From: Patel, Uday [Uday.Patel@lancashire.gov.uk]
Sent: 22 February 2013 11:34
To: Claire Booth
Cc: planning
Subject: consultation response - 3/2013/0064 - Conversion of the former garage premises to form a bungalow (resubmission) - Former Garage Branch Road Waddington

Planning Application Reference: 3/2013/0064
Proposal: Conversion of the former garage premises to form a bungalow (resubmission)
Location: Former Garage Branch Road Waddington

PROPOSED PLANS, ELEVATIONS, & SECTION A-A	
Site: Conversion from a garage to a bungalow, The Garage, Branch Road, Waddington, Lancashire	
Client: Mr Colin Taylor	
Date: 09.01.13	Scale: 1:100 @ A2
Project No: TAYLO/02A Dwg 02	Drawn: ML / NYB
Amendments:

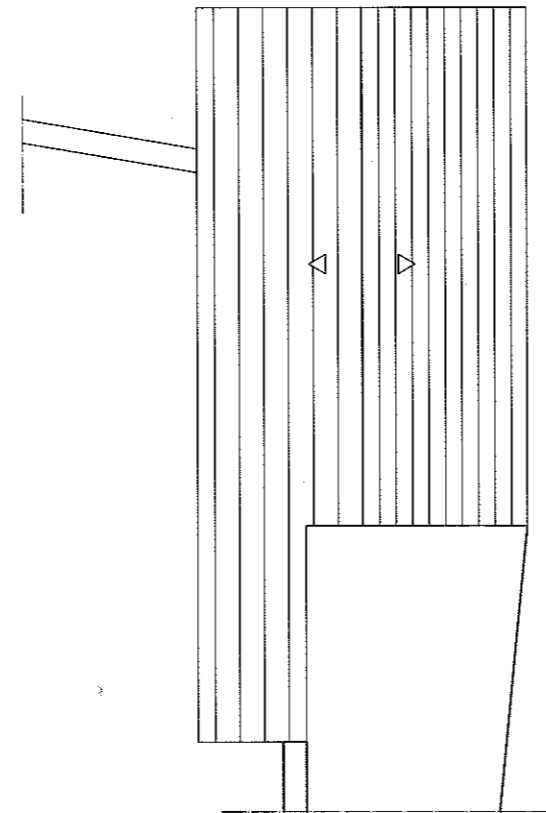
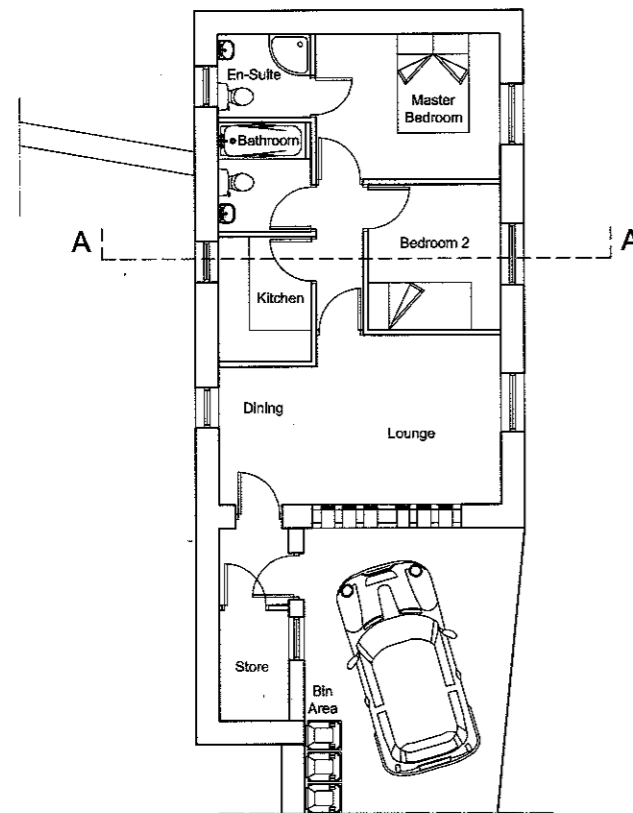
1. The existing garage door is a wide double flap door. The parking space as indicated in front of the garage is likely to be affected by the opening/operation of the door. This situation may leave the vehicle to overhang on the highway beyond the existing concrete hard standing and may be even beyond the curtilage of the property on to the highway. Since the applicant has indicated to retain the garage door, it raises the concern that this situation may cause hazardous condition to other public road users. Therefore it is required that the existing garage door be permanently replaced by a fixed fixture/alternatively made for not to interfere with the tight parking space and avoid and hazardous situation on the adjacent public road.

2. The access door to the dwelling is presumably from the side of the store room. This door as indicated in the plan is opening away from the parking space in front of the garage. This is acceptable.

3. The wheelie bins are presumed to be stored within the store room at all times and brought out only on the day of collection. Location of bins outside the store room is likely to affect the parking space and opening the car doors etc which may force the car towards the public highway.
